From: Liz Annalls [REDACTED]
Sent: 25 June 2020 06:58
To: Planning.Responses <Planning.Responses@arun.gov.uk>
Subject: RE: Planning Consultation on: LU/152/20/RES

App No: LU/152/20/RES
Address: Fitzalan Link land between A259 Worthing Road & East Street/ Fitzalan Road Roundabout Littlehampton
Proposal: Approval of reserved matters following LU/63/11 & LU/234/16/RES for construction of Fitzalan Link Road between A259 Worthing Road & the East Street/Fitzalan Roundabout. This application affects a Public Right of Way. This application is not CIL Liable as other development (Zero Rated).

Drawing Title:
PROPOSED S38/S278 HIGHWAY WORKS
FITZALAN LINK
LANDSCAPE PROPOSALS 1 OF 2

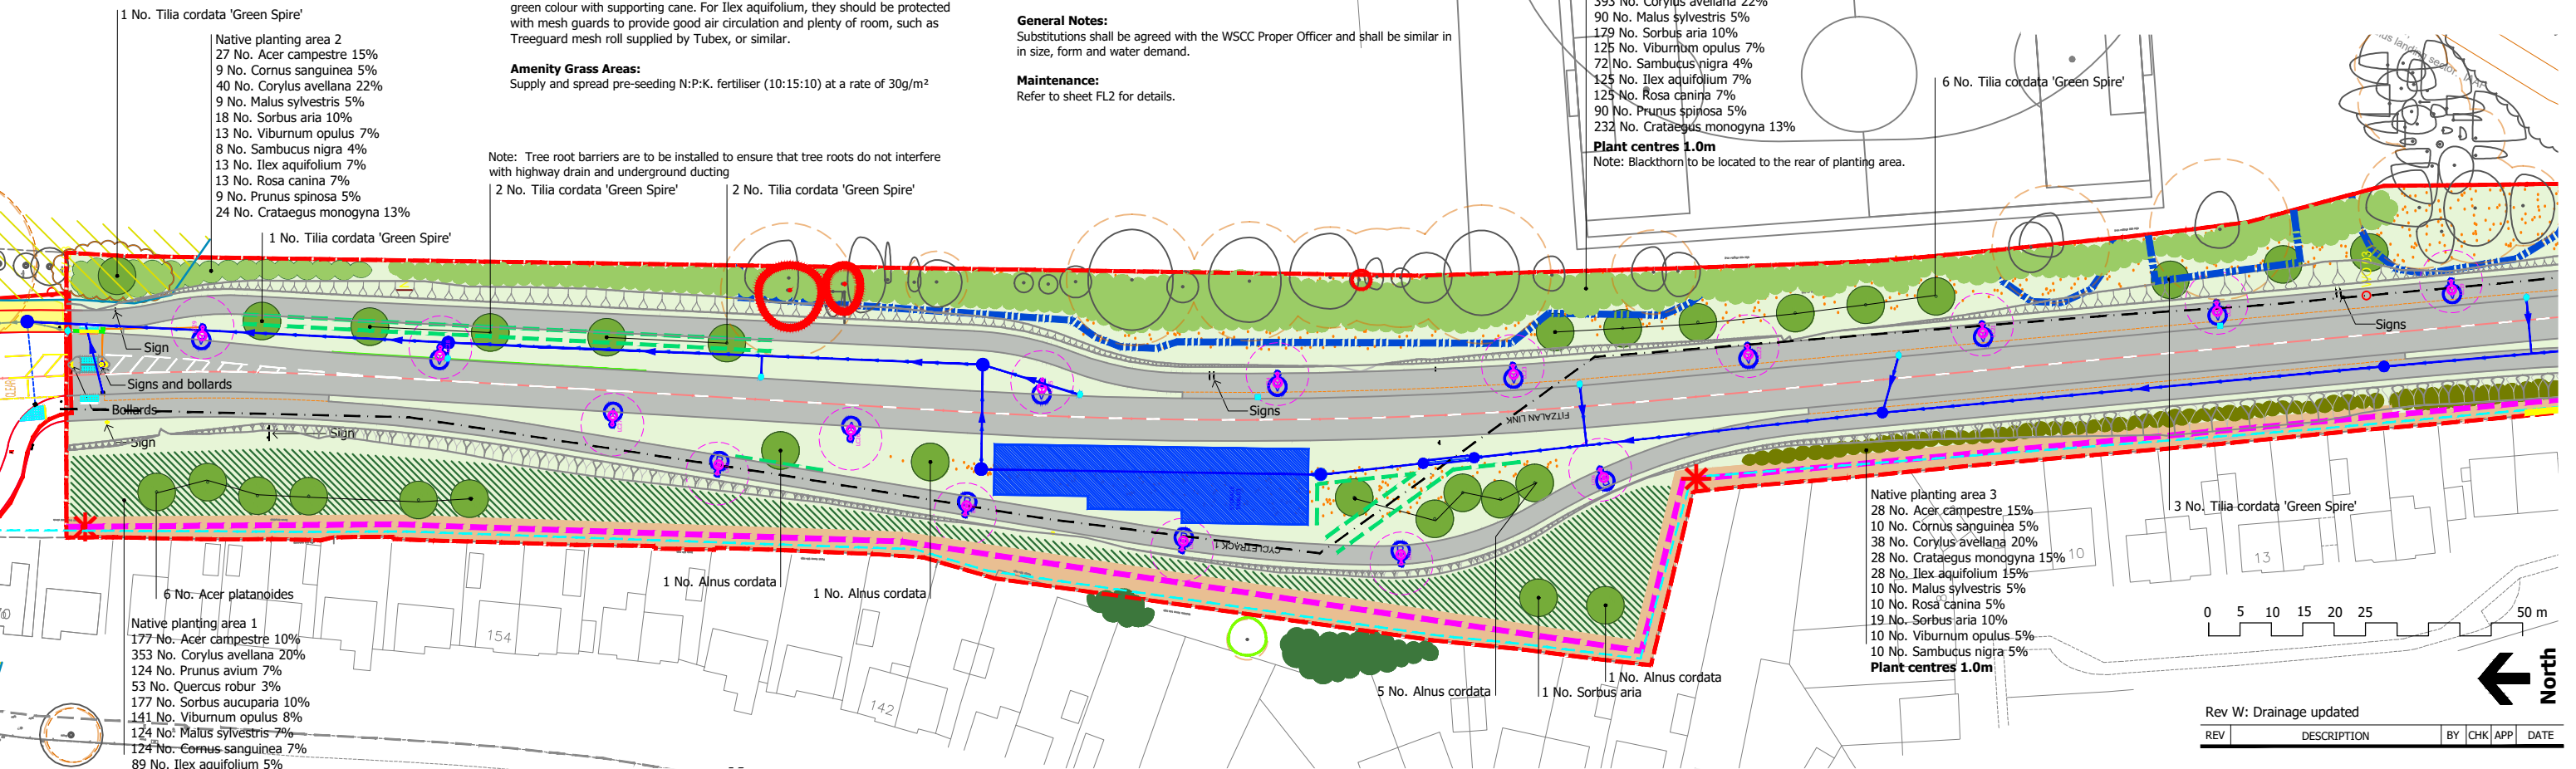
As detailed within the Reptile and bat Survey email (Dec 2015) which was submitted with the LU/234/16/RES application, a number of recommendations were made for the landscaping scheme which will need incorporating into these plans including;

- Tall mature trees retained and planting to create vegetated hop-over over Fitzalan link road
- Planting flora species to increase food sources of bats

The lighting scheme for the site will need to take into consideration the presence of bats in the local area and the scheme should minimise potential impacts to any bats using the trees, hedgerows and buildings by avoiding unnecessary artificial light spill through the use of directional light sources and shielding.

We would like a variety of bird boxes installed within the trees surrounding the link road.
